OFFICIAL NOTIFICATION OF DECISION

Project# PR-2023-008906
Application#
SD-2023-00168 – PRELIMINARY/FINAL PLAT

TRACTS 1 & 2, JONES INDUSTRIAL PARK
zoned **NR-LM**, located on **VASSAR DR NE**
between PHOENIX AVE NE and LOS
ARBOLES NE containing approximately
1.0324 acre(s)

SKETCH PLAT FOR
 LOT 1-A
 JONES INDUSTRIAL PARK
 SITUATE WITHIN
 SECTION 10, T. 10 N., R. 3 E., N.M.P.M.
 CITY OF ALBUQUERQUE
 BERNALILLO COUNTY, NEW MEXICO
 JUNE 2023

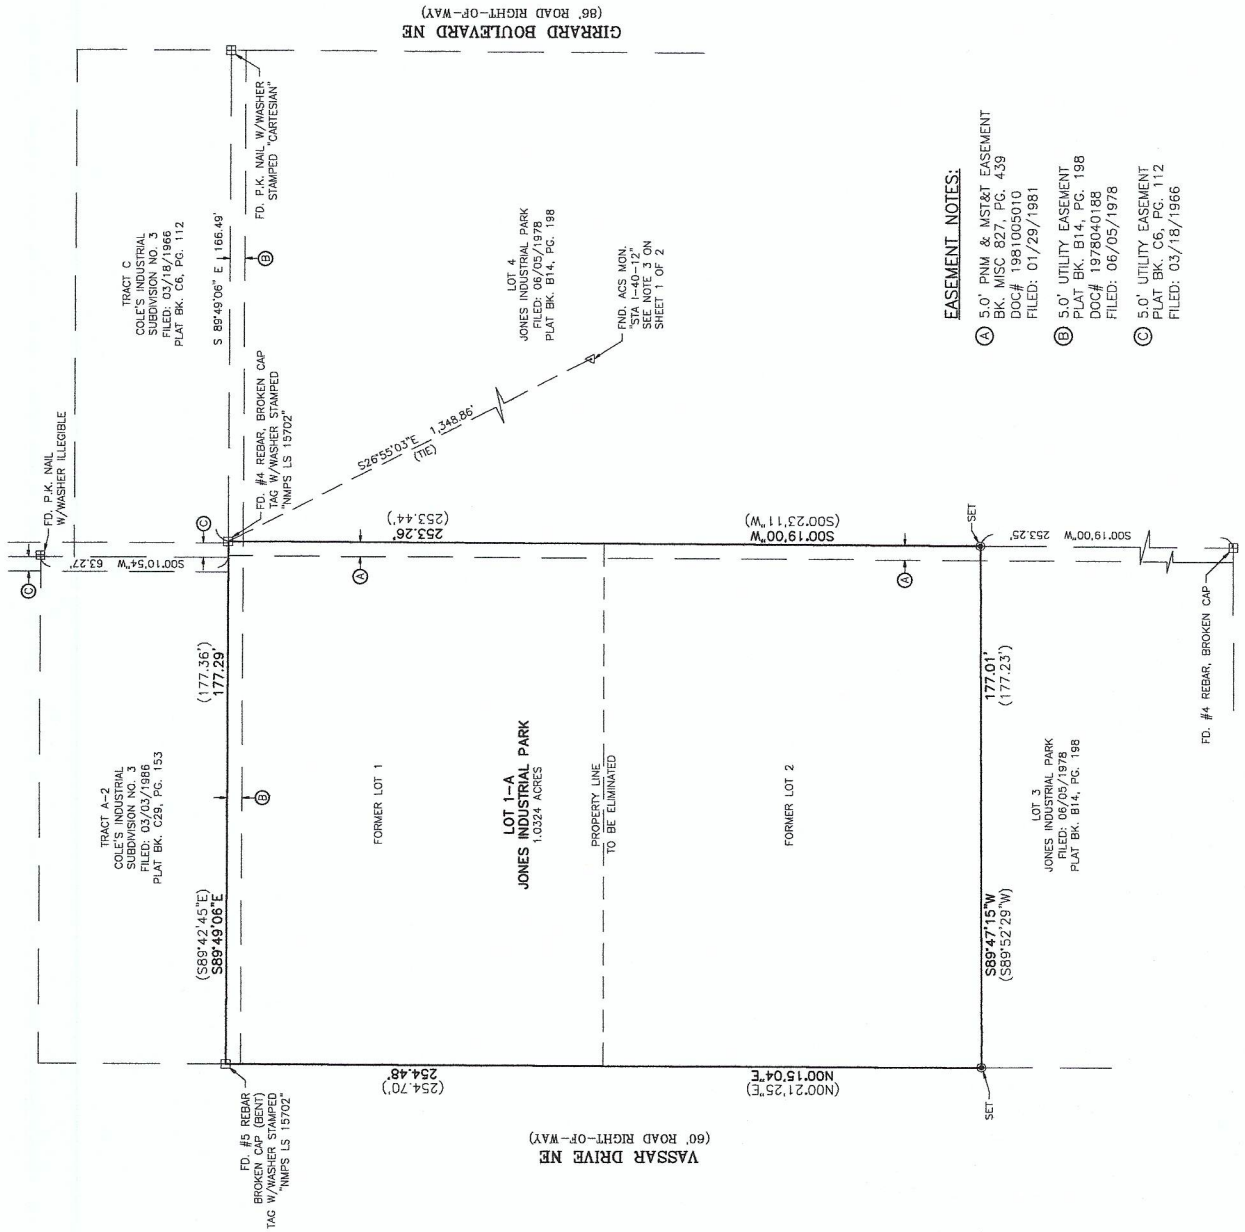
- a. An updated Plat depicting the correct 5-foot sidewalk width must be submitted.
- b. Please add the following note regarding this item to the title/cover page of the plat:
'The subject property is located within the Menaul and University Landfill Buffer. Therefore, certain precautionary measures need to be taken to ensure the health and safety of the public. As required by the most current version of the interim Guidelines for Development within City Designated Landfill Buffer Zones, A professional engineer with expertise in landfills and landfill gas issues will be consulted prior to the development of the site.'
